AL/143/24/RES

Outline Conditions

Senior Officer Comments

Title: Play and Open Space Proposals
Sheet 1

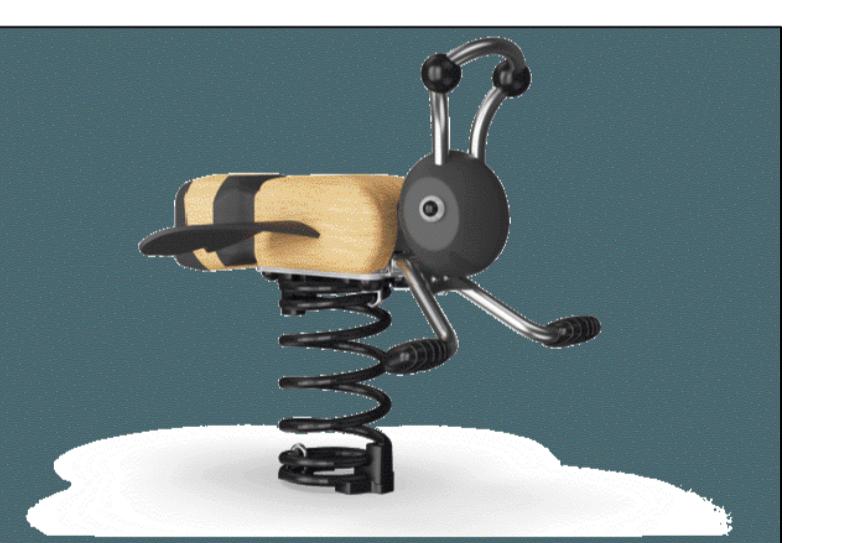
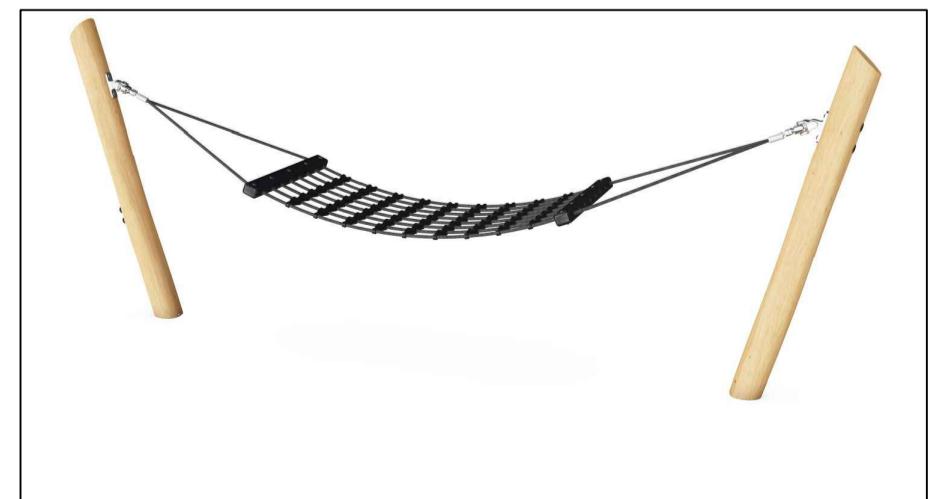
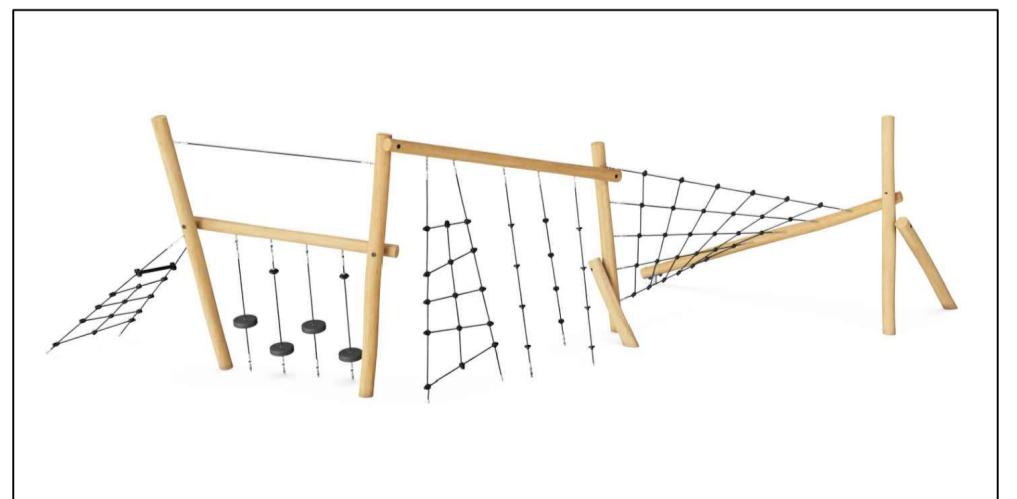
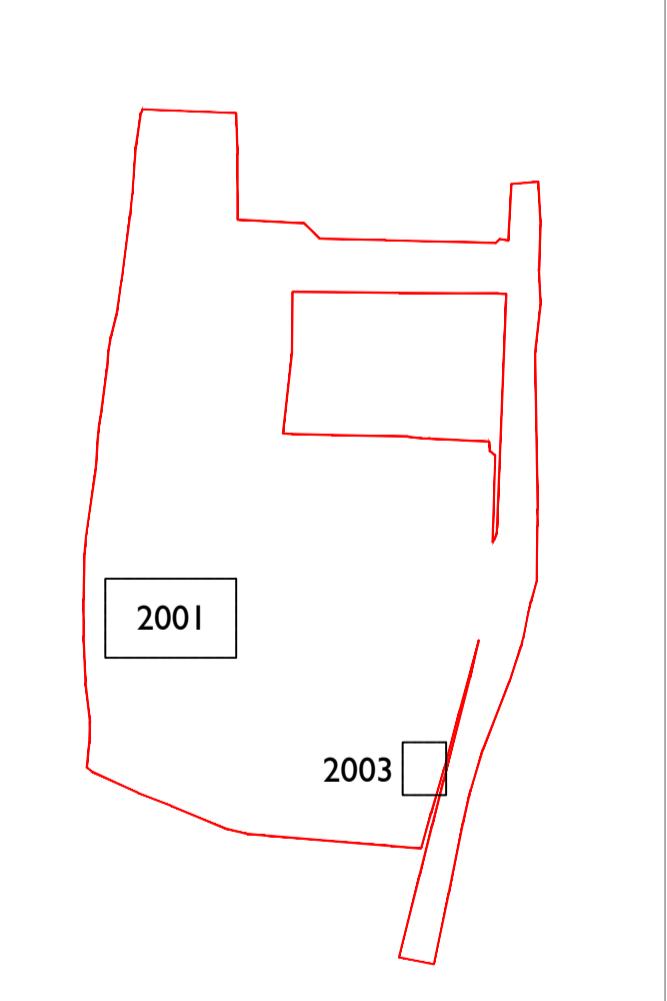
Need 7,838m2 of POS and Play provision to include 2 x LAP and LEAP (400m2). Provide LEAP and 2 x LAP (which are all spread out) and state they meet the POS requirements **but no info on proposed amount of open space in m2 (no breakdown of areas to check whether useable)**. Await Landscape comments
No detailed drawings of landscaping yet landscaping applied for (await Landscape comments).
Applicant response: A landscape area calculation is now included, showing that landscape/open space provision meets required standard. Detailed planting plans are being prepared
